CITY OF ALBUQUERQUE

March 13, 2013

**Re: Santuario de San Martin De Porres, Grading and Drainage Plan
Engineer's Stamp Date 3/16/2013 (M10/D002)**

GRADING AND DRAINAGE PLAN

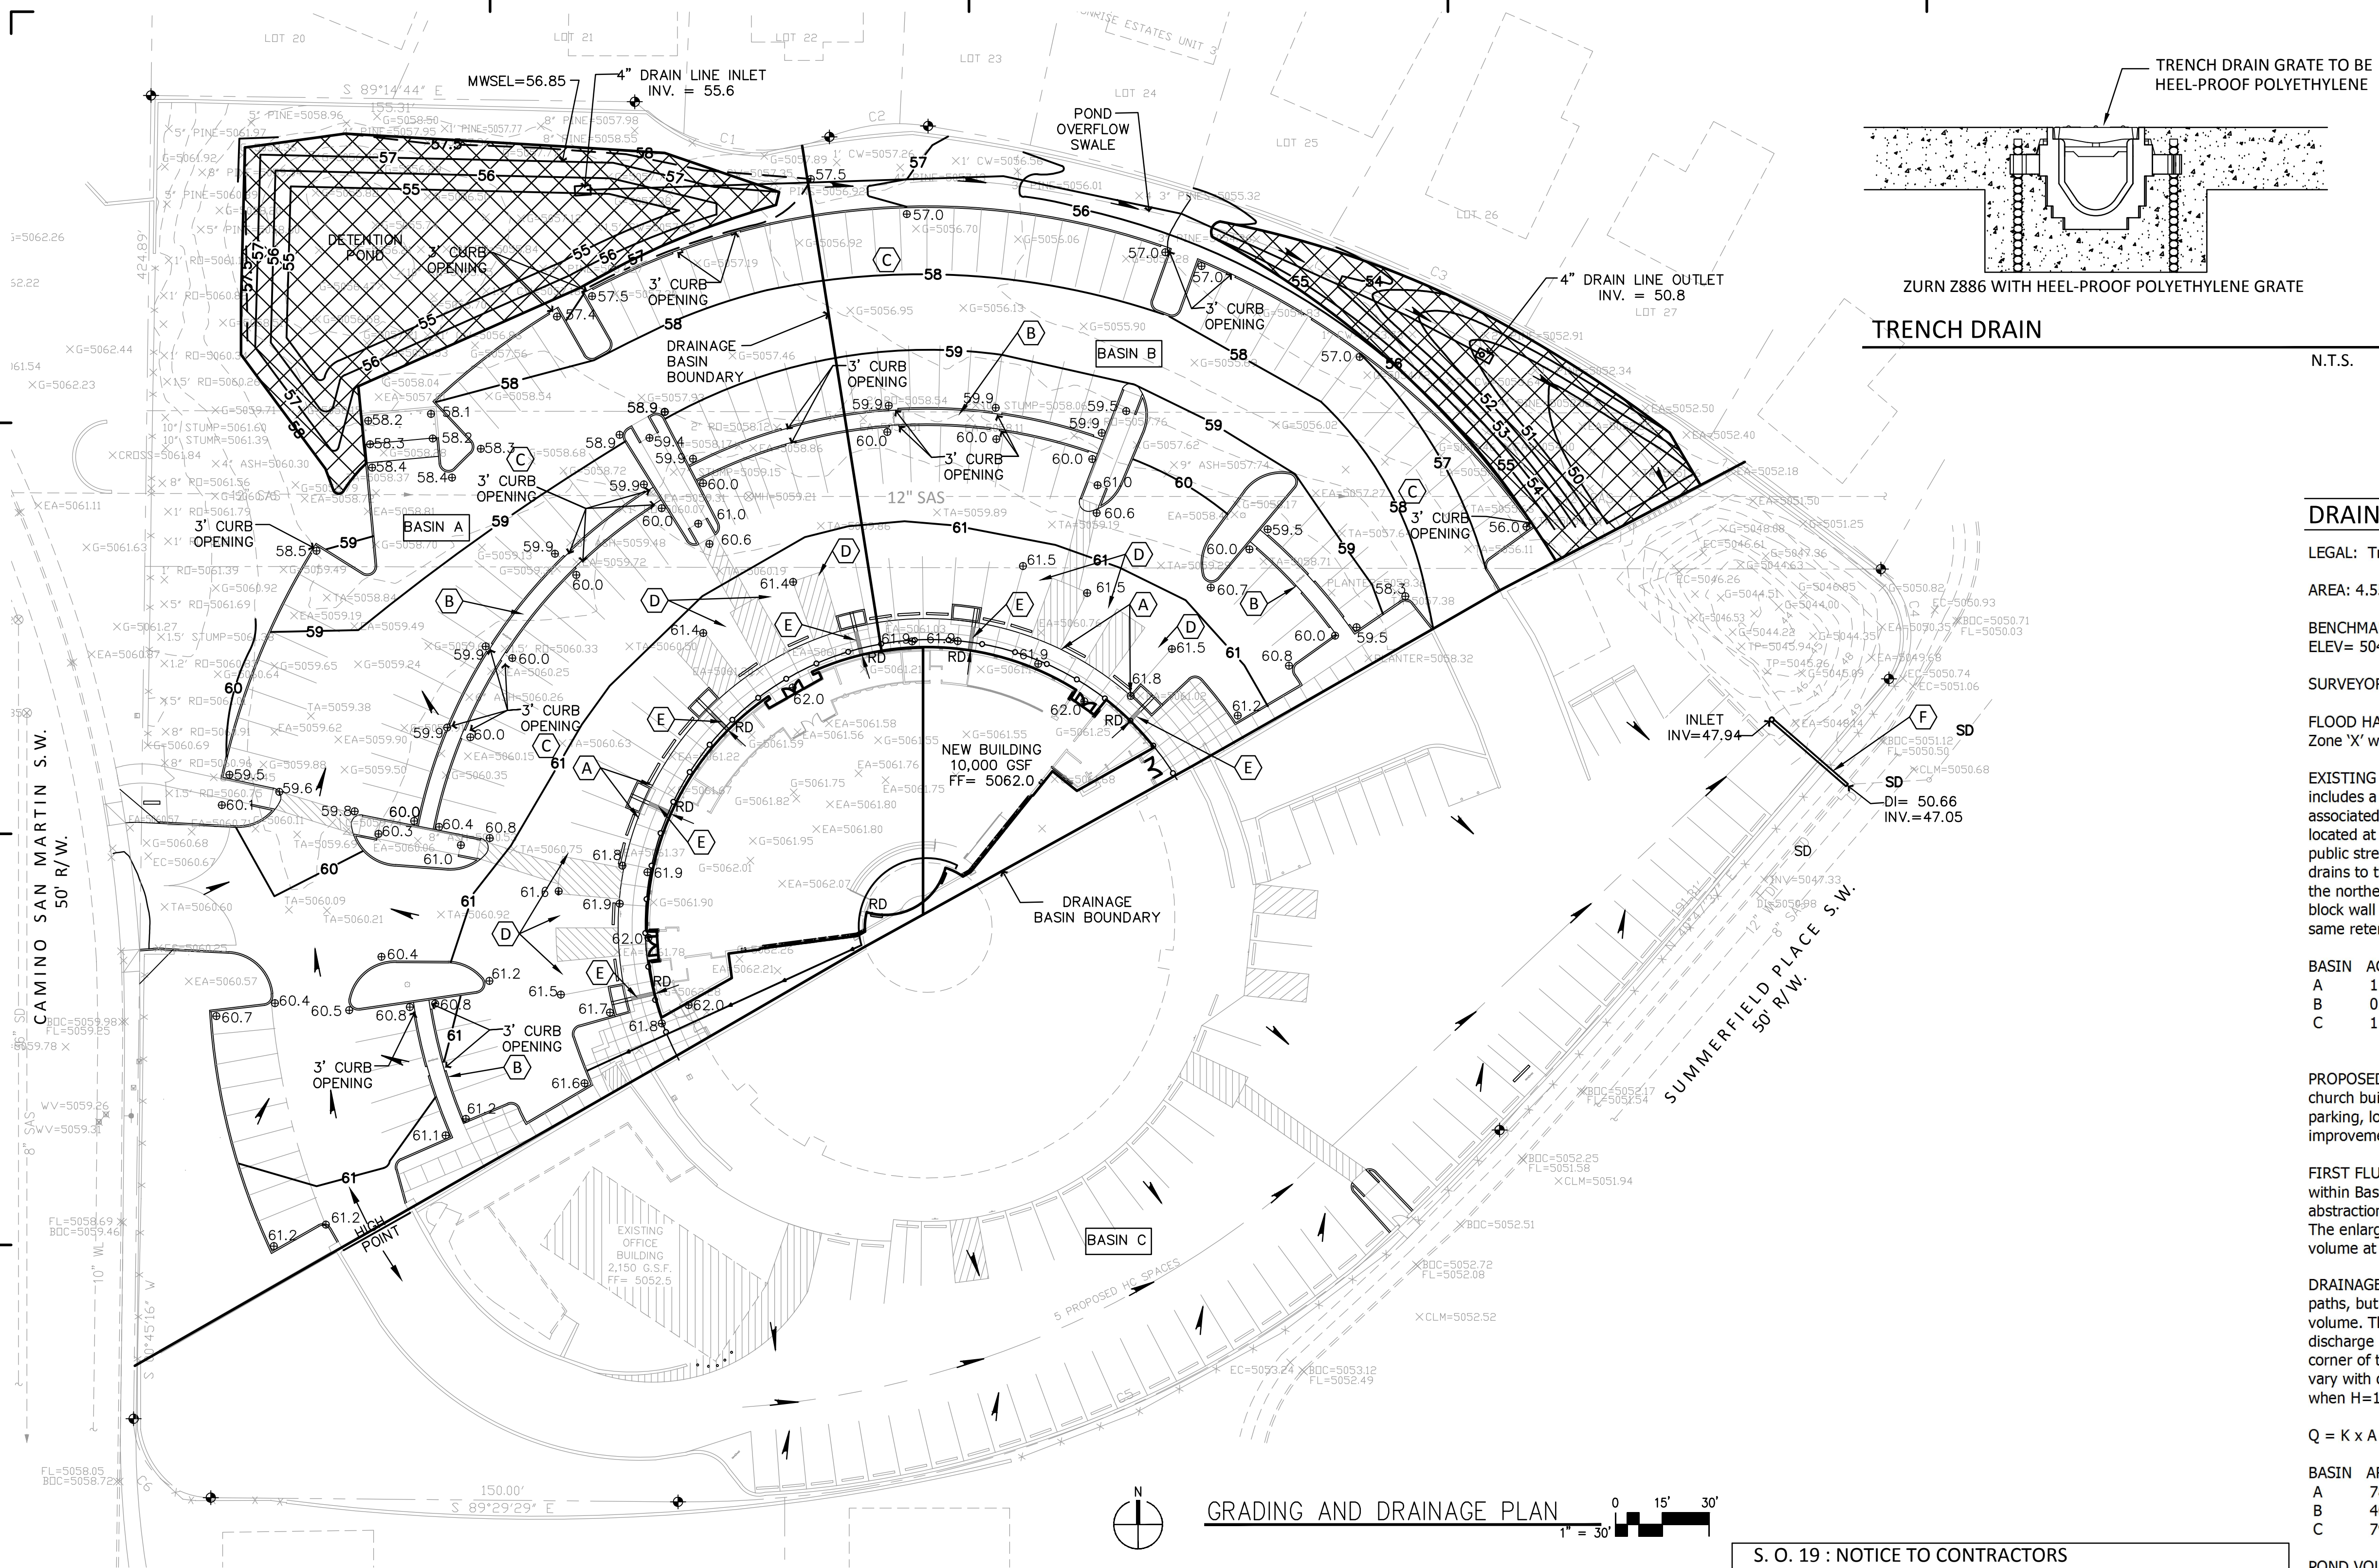
- Provide more spot elevations to assure that the runoff drains to the existing retention pond. Include the runoff and volume calculations for the basin that drains to the existing retention pond.
- Provide pond volume calculations to assure that the existing retention pond is designed for the 100-year/10-day volume.
